Recommendation Report for Planning Permission

REF NO: LU/244/13/

LOCATION: Land Parcel 1B
Courtwick Lane
Land south of Railway Littlehampton

PROPOSAL: Application for approval of reserved matters following outline application LU/355/10 for the appearance, landscaping, layout and scale of 70 dwellings (including 20 affordable dwellings) within land parcel 1B. Departure from the Development Plan.

Rev.	Date	Description	Drawn	Checked
Client Bellway aap architecture				
Project Courtwick Littlehampton				
Drawing Title Parking Layout Phase 1B / 2				
Scale	1:500 @ A2		Drawn	Checked
Date	Aug 2013		BAS	DGP
Drg.No.	P802/BEL/PH1/06		File	P802-Ph 1B Layout Drawing Status
			Rev.	PLANNING

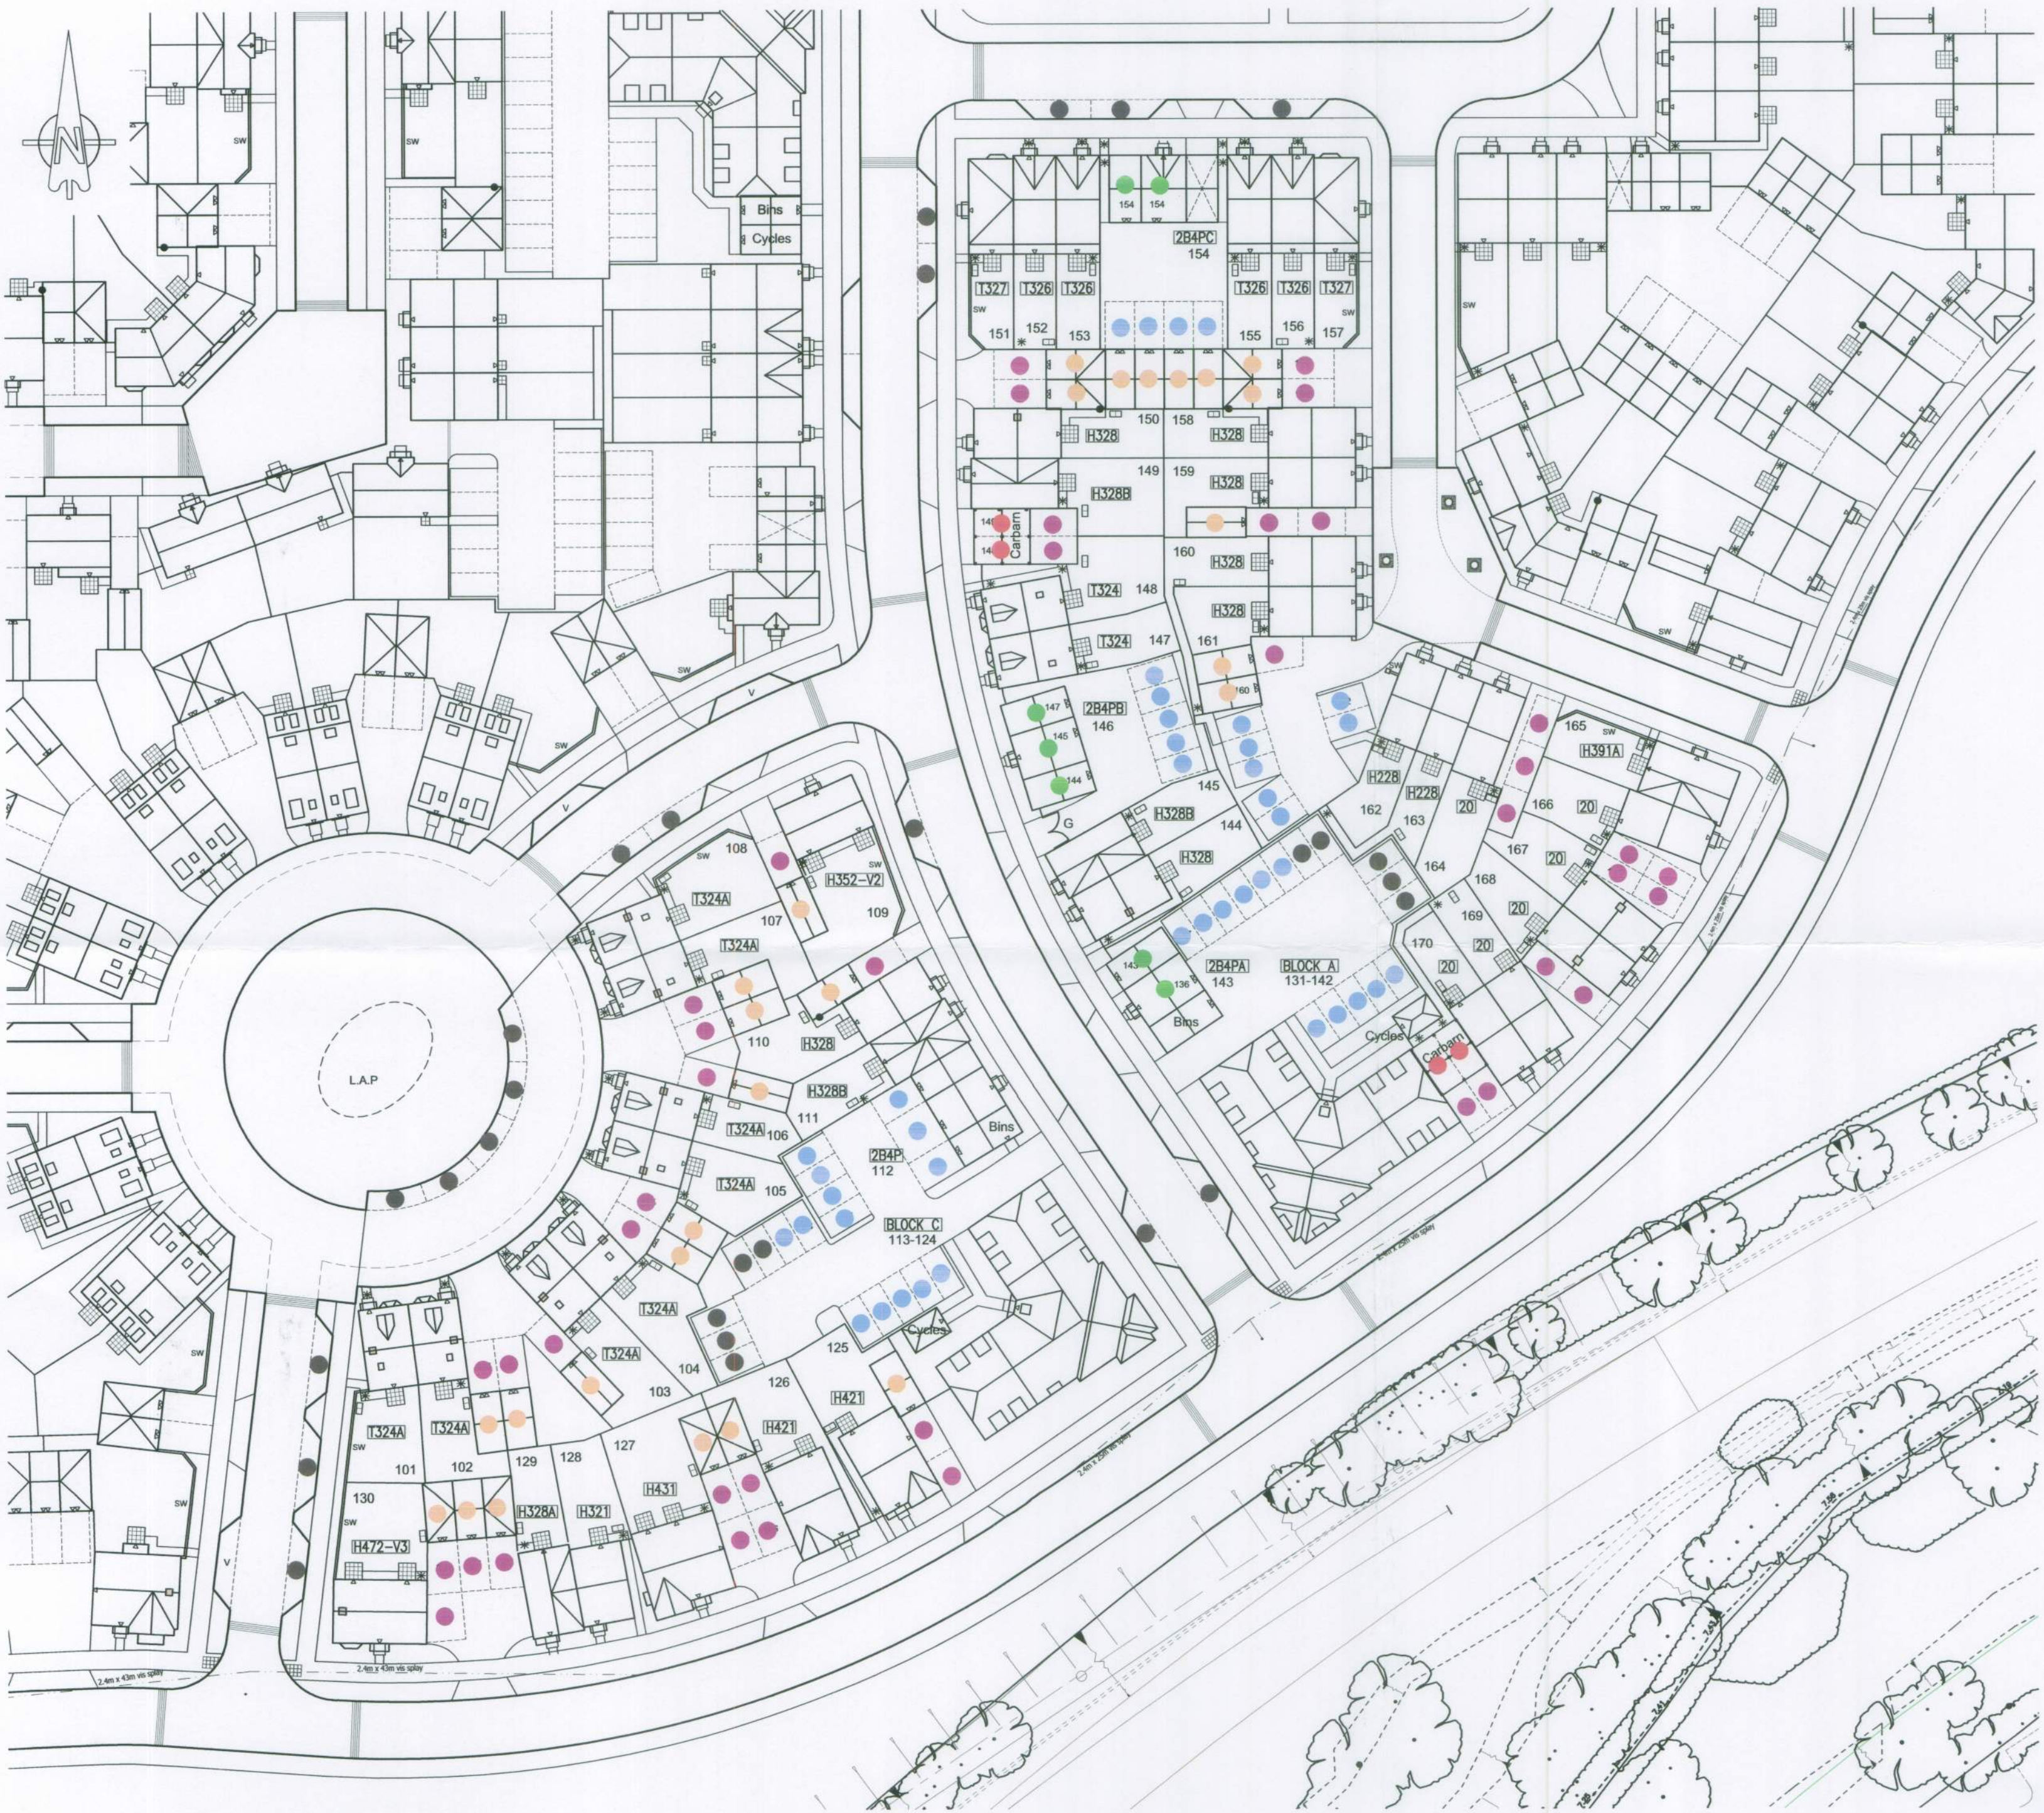
There are over two off-street parking spaces per dwellings on average and all dedicated parking spaces for the dwellings measures approximately 3m x 5.5m per space (comfortably above the minimum standard). A few parking courts are proposed, principally behind the two proposed apartment blocks. These areas have slightly smaller car parking spaces but all are a minimum of 2.5m x 5m (above the minimum guidelines contained in Manual for Streets). Further, there are unallocated on-street parking spaces within off-set bays so as not to cause parking that will obstruct the highway.

The WSCC Parking Calculator has been used to verify the on-site parking provision. The combined layouts provide 351 allocated parking spaces and 50 unallocated spaces. Using the calculator, this suggests that 375 spaces should be allocated and 37 unallocated. In overall numbers, what is provided (401) compares very favourably to the 412 as suggested by the Parking Calculator. A 10% margin (either way) is generally considered acceptable when using the Parking Calculator. Furthermore, a large number of the properties have their parking configured in such a way as to informally provide further off-street parking provision. This further reinforces the County's view that parking provision for both layouts is acceptable.

Scale	1:500 @ A2	Drawn	BAS	Checked	DGP
Date	Aug 2013	File	P802-Ph 1 Layout	Drawing Status	
Drg.No.	P802/BEL/PH1/01	Rev.	B	PLANNING

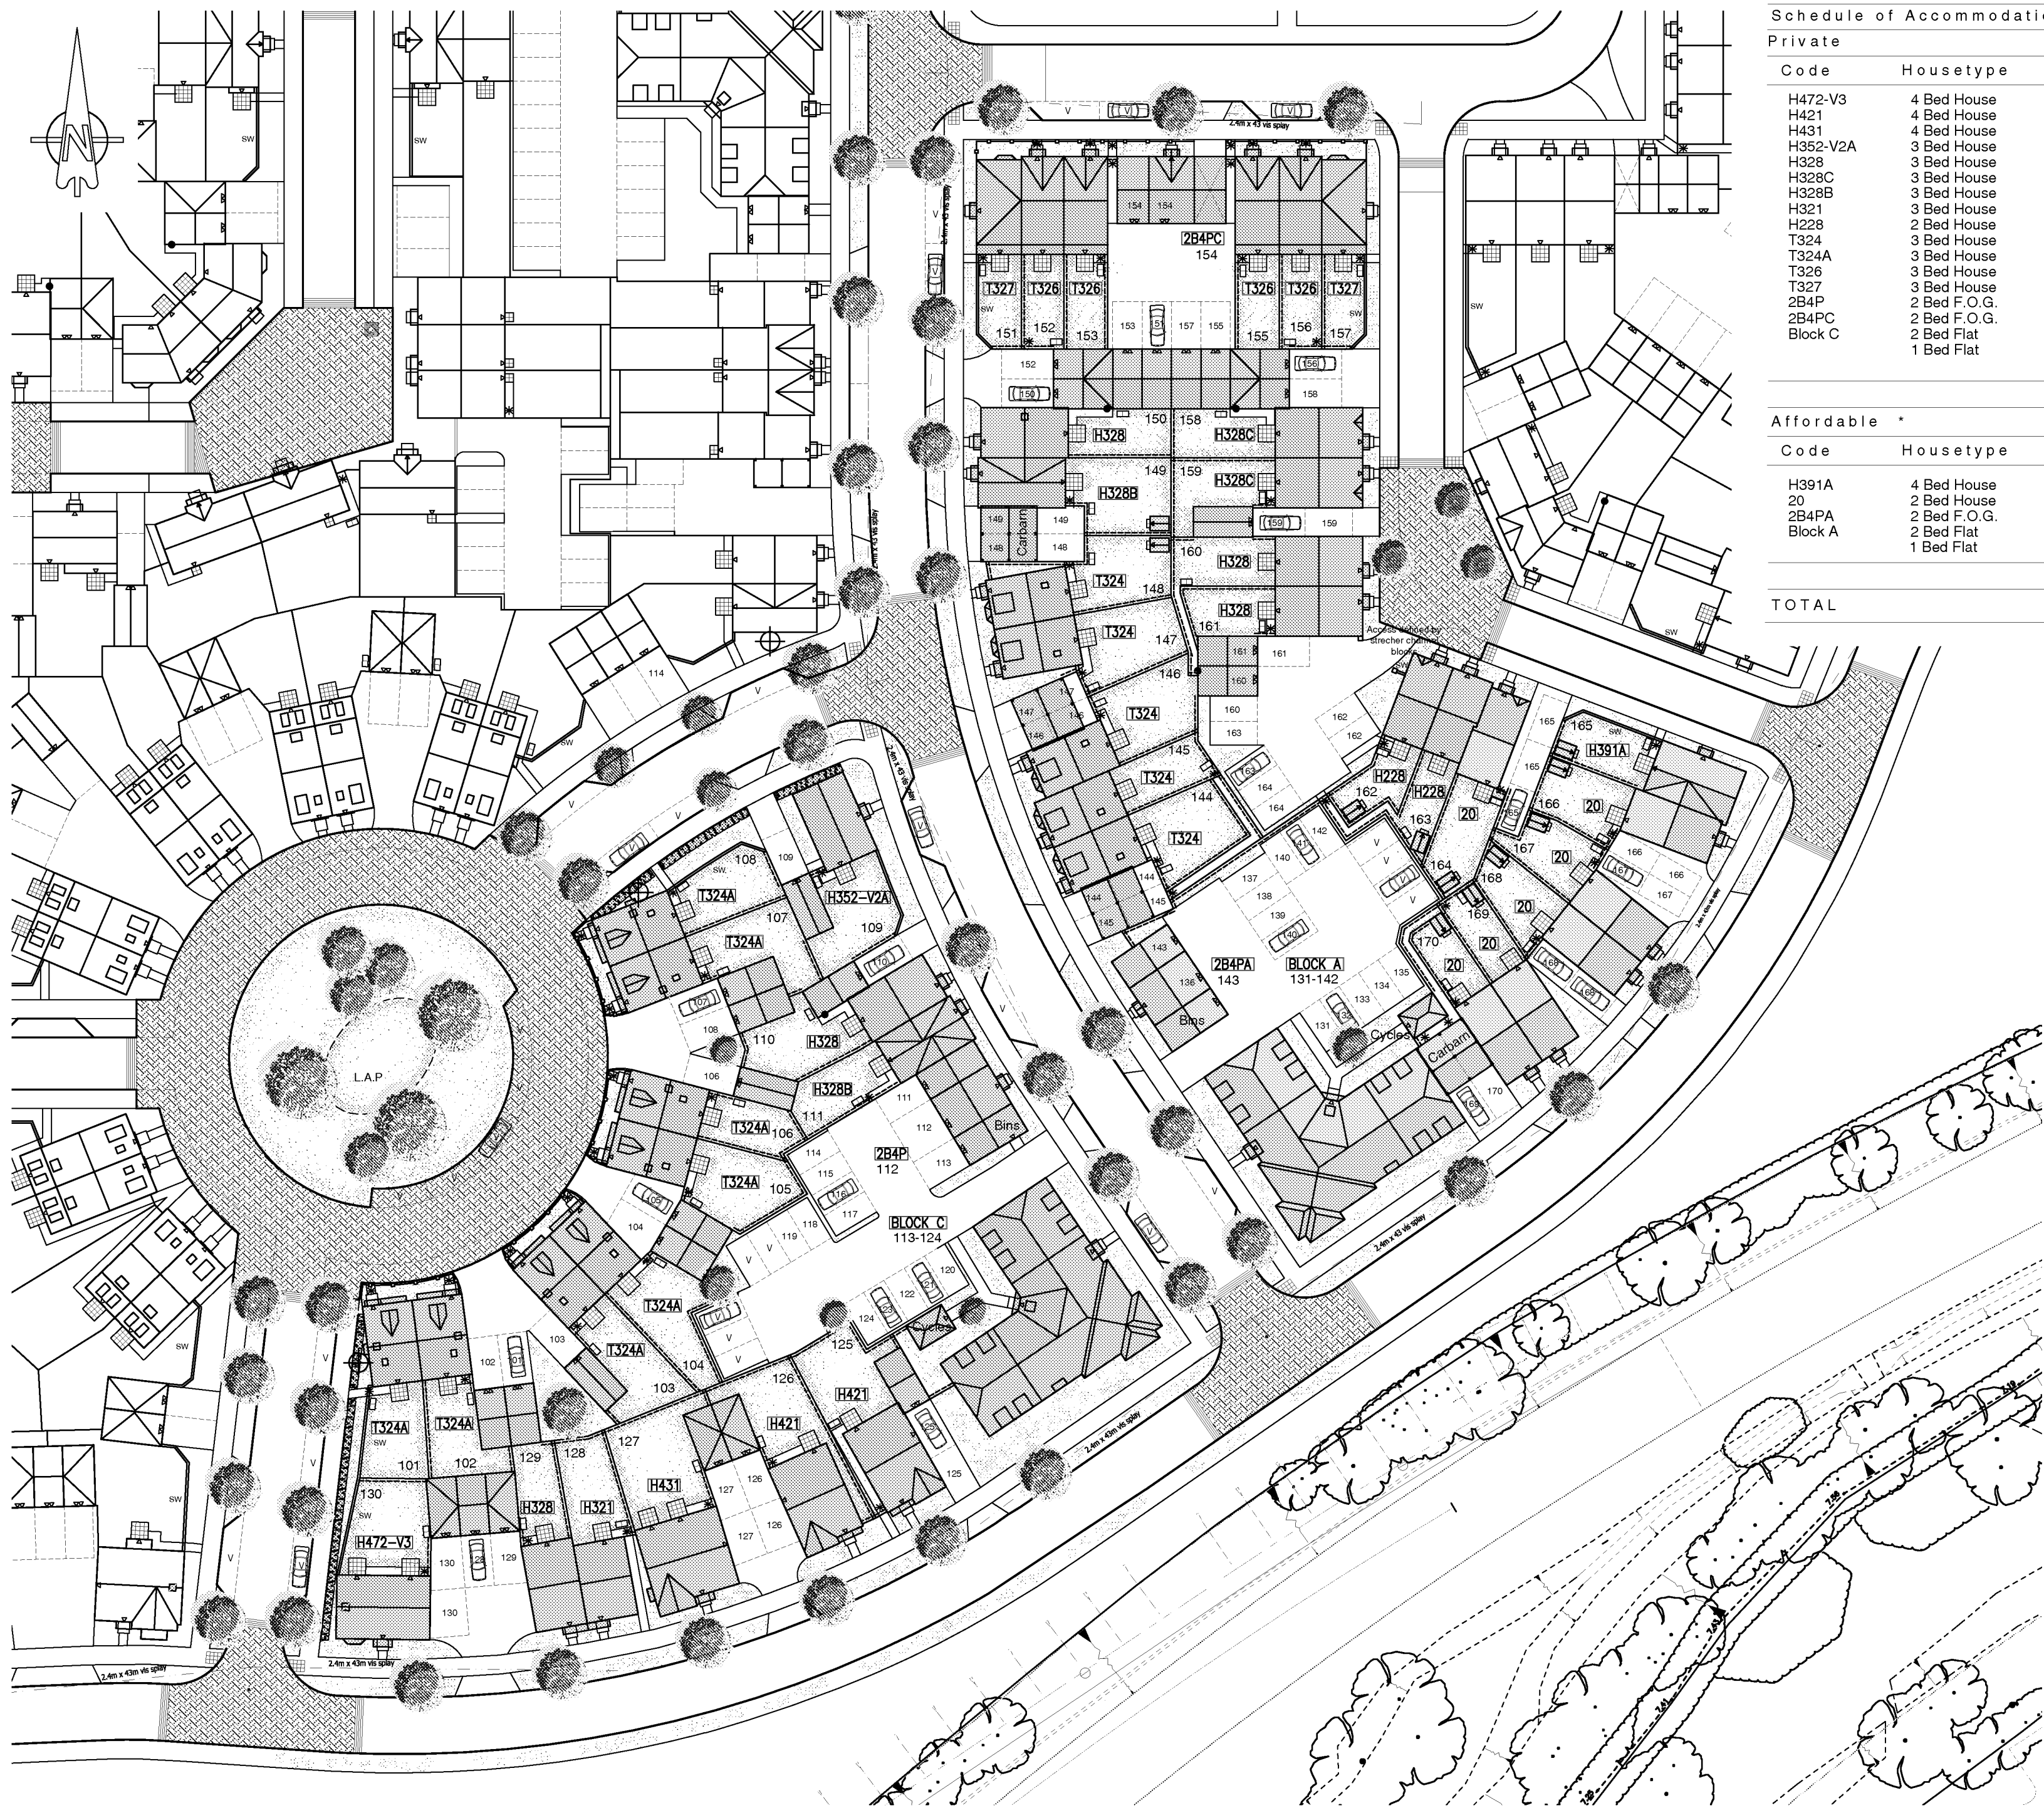
WSCC (Highways) - No objection. Initially some minor amendments required in respect of sight lines at junctions, tactile paving and access to parking areas. Clarification also sought that route for buses will be 6m in width. Following receipt of amended details concerns in respect of sight lines, tactile paving and parking areas are addressed.

Sussex Police - Concerns over rear parking courts. In the main, development create good active frontages with in-curtilage parking. However, there are 5 parking courts that I have concerns over and consideration should be given to gating these.

These proposals as originally submitted were improved on the previously refused proposals. However, officers still raised a number of concerns with the design. The majority of these were very minor but there were still some issues with how different areas were treated and ensuring that variety and quality were achieved. In summary, these concerns relate to;

- the 'mews' style areas of the scheme requiring greater variety but, at the same time, ensuring that those similar areas across the two proposals are consistent in style.
- the 'streets' are designed to be different to the 'A259 frontage'.
- removal of dead frontages on the 'boulevard' and ensuring that the scale and uniformity of a 'boulevard' is included in the designs.
- some re-designing of the taller units and incorporating designs that turn corners.
- front doors to apartment blocks.
- increasing landscaping strips to the street adjacent to side garden walls.

These concerns have been expressed in detail with the applicant and, at the time of writing, formal amendments have yet to be submitted. However, officers have informally commented on proposals and are satisfied that the proposals will address the original concerns.

- Included higher quality 'mews' areas with more housing containing design details (details that are specific to such areas) that result in a lower scale area of more informality.
- The boulevard has been addressed through the introduction of more house types of a suitable scale and some units with 'dead frontages' have been removed - those that remain have incorporated good brick detailing at ground floor.
- The entry frontage is now an area of similar housing (in scale and form) but with variety between house types and suitable 'feature' properties at suitable locations.
- Areas where garden walls address the street are given more space for landscaping
- Dwellings on corner plots now turn those corners in a much better way.
